PORTLAND MAINE

July 15, 2011

RE: 99 Wellington Road – 141-D- 8, 9, 10 – R-3 Zone – Determination Letter

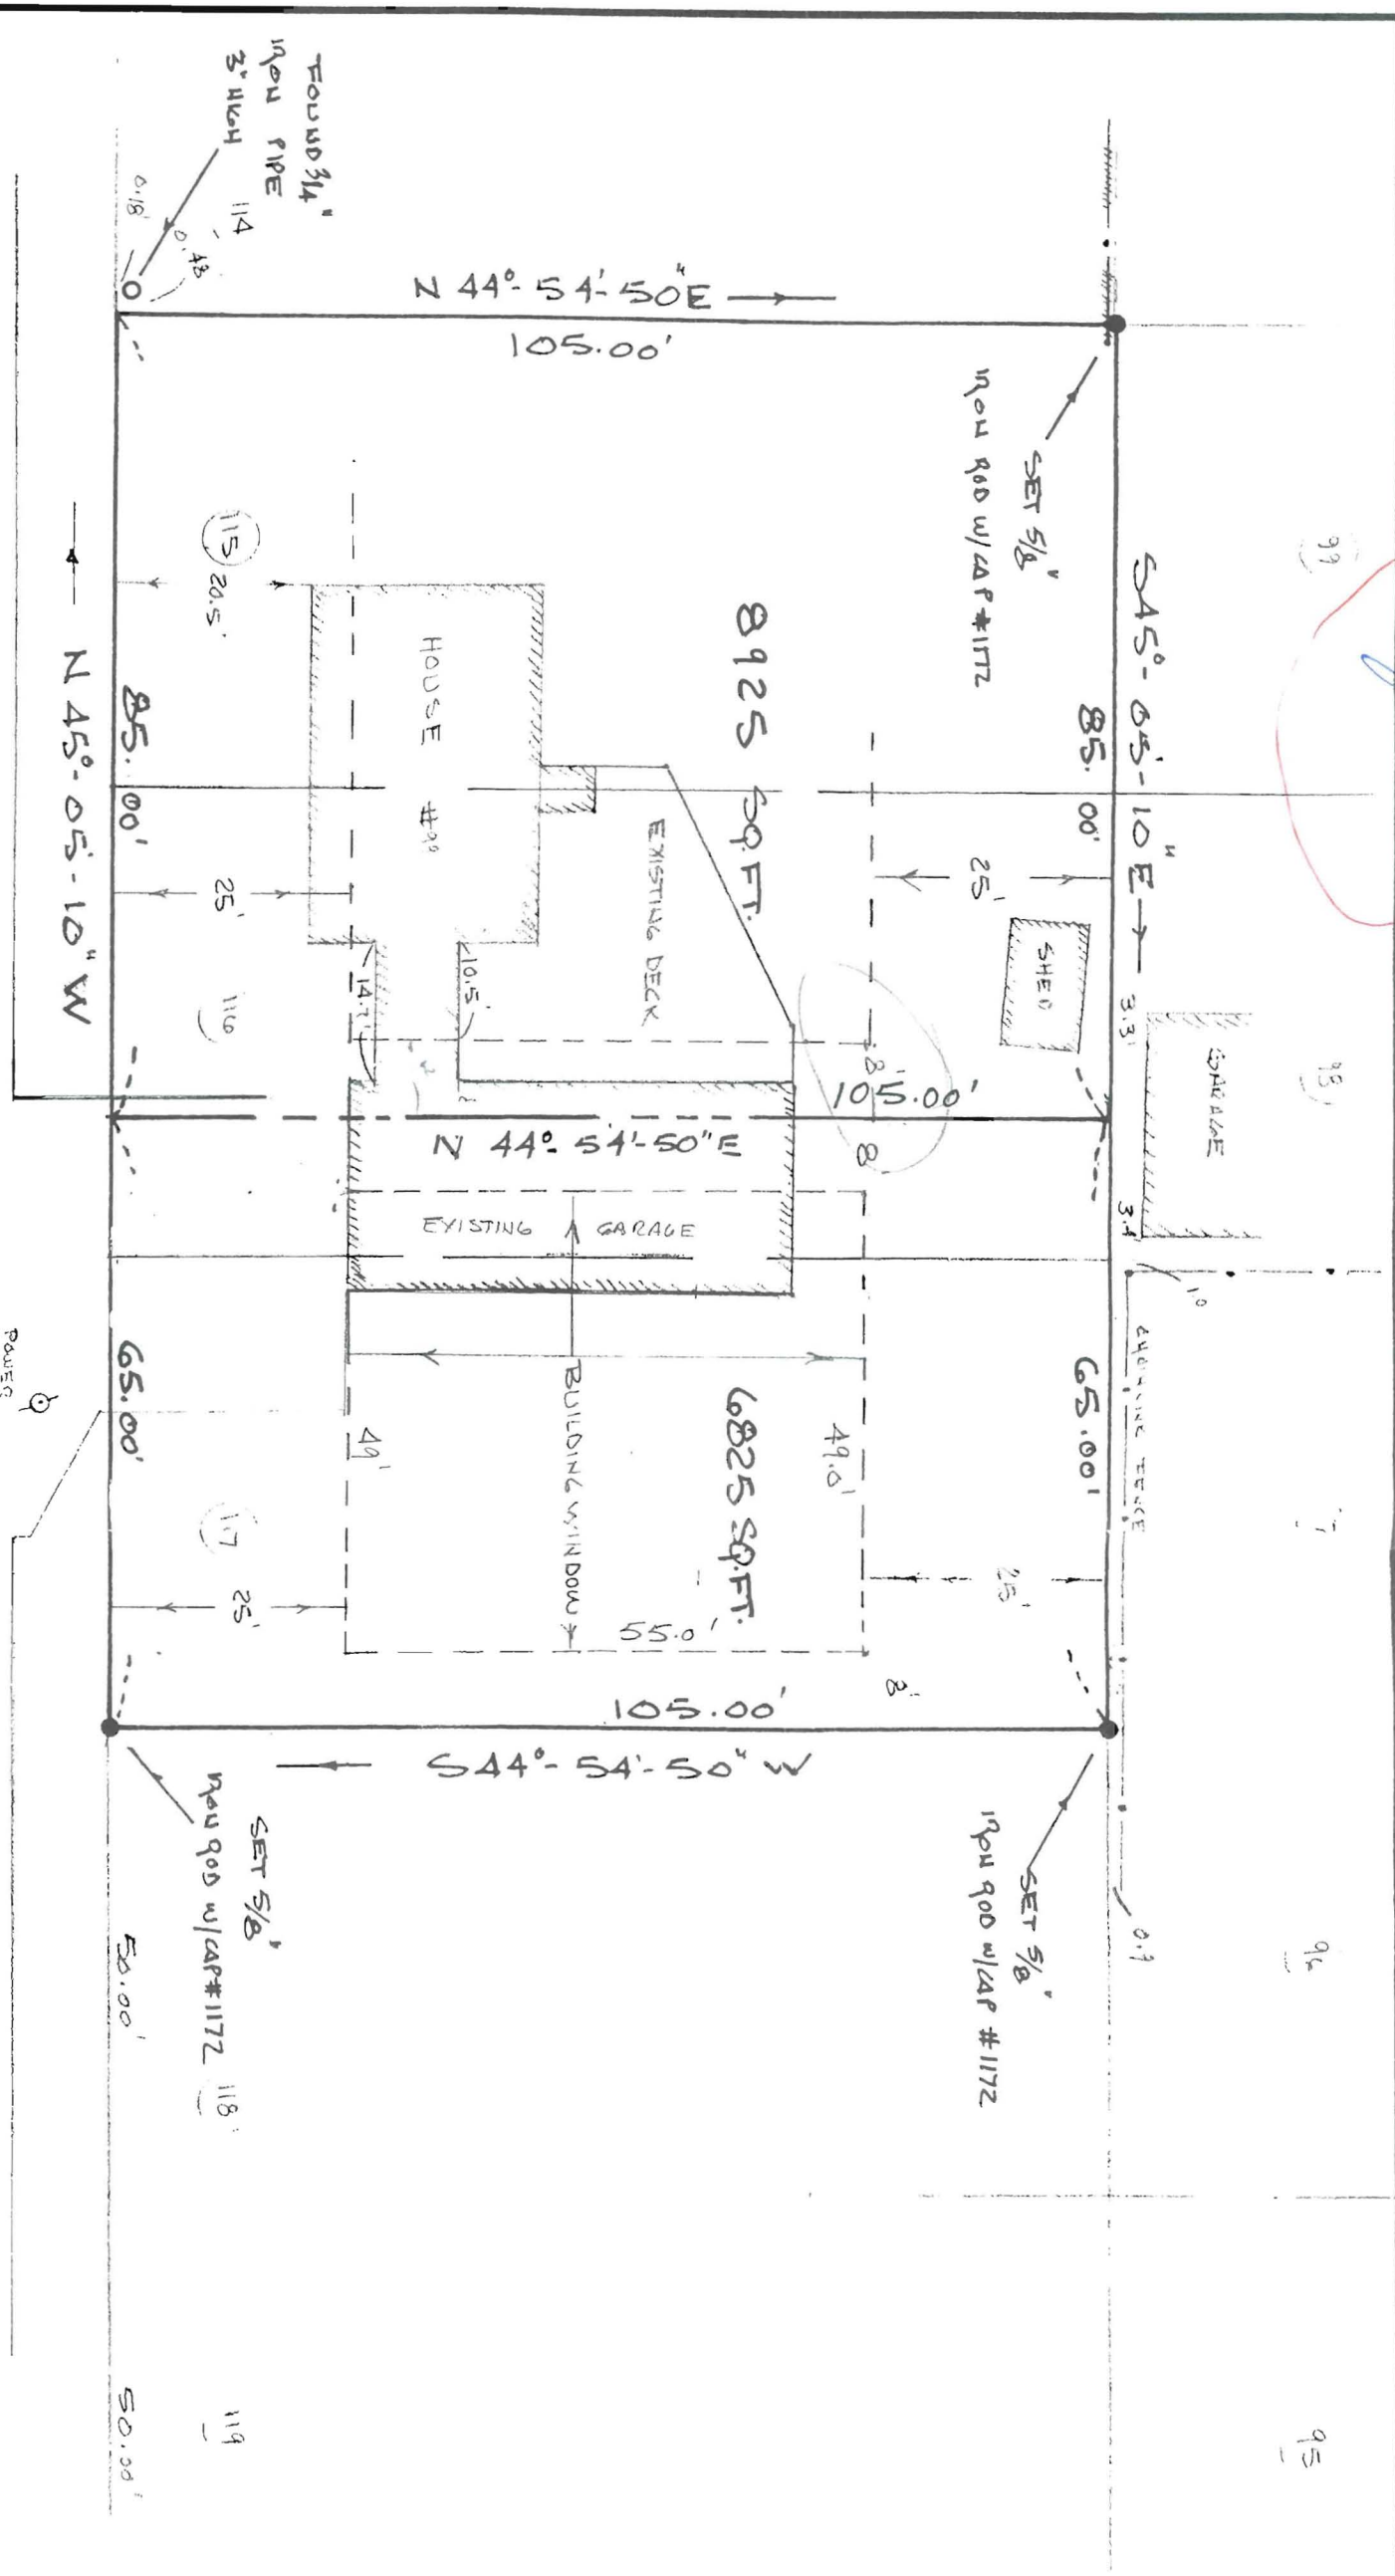
The property is located in an R-3 residential zone. I have reviewed the most recent plans submitted for review on July 7, 2011. My determination is based upon a survey submitted which is a copy of a signed, stamped survey by Daniel J. Dalfonso LLC and dated 11-03-08. It is noted that Daniel J. Dalfonso did not personally redate or resign the revised survey.

I have reviewed both lots, the lot with the existing single family, single story ranch and the proposed vacant lot. Based upon what is shown for the demolition of an existing garage and connector and portion of a deck, both lots meet the underlying R-3 zone dimensional requirements. The proposed lot can meet the requirements of the R-3 zone at such time that a permit is requested. And the remaining house lot meets the R-3 zone.

Please note that this determination is conditional. There *shall* be a permit for the demolition work. The proposed structures shall be removed as shown on the submitted survey *before* the vacant lot is conveyed or registered in the Registry of Deeds.

This determination is also contingent upon the accuracy of the submitted plans. If Mr. Dalfonso did not make the alterations that are shown on the survey, and the plans were simply altered by another individual, the accuracy can be called into question. Certainly, prior to a building permit for the proposed vacant lot, a full, updated survey would be required. This determination does not substitute the requirement for permits prior to any new construction. All permits and site plan review(s) shall be required.
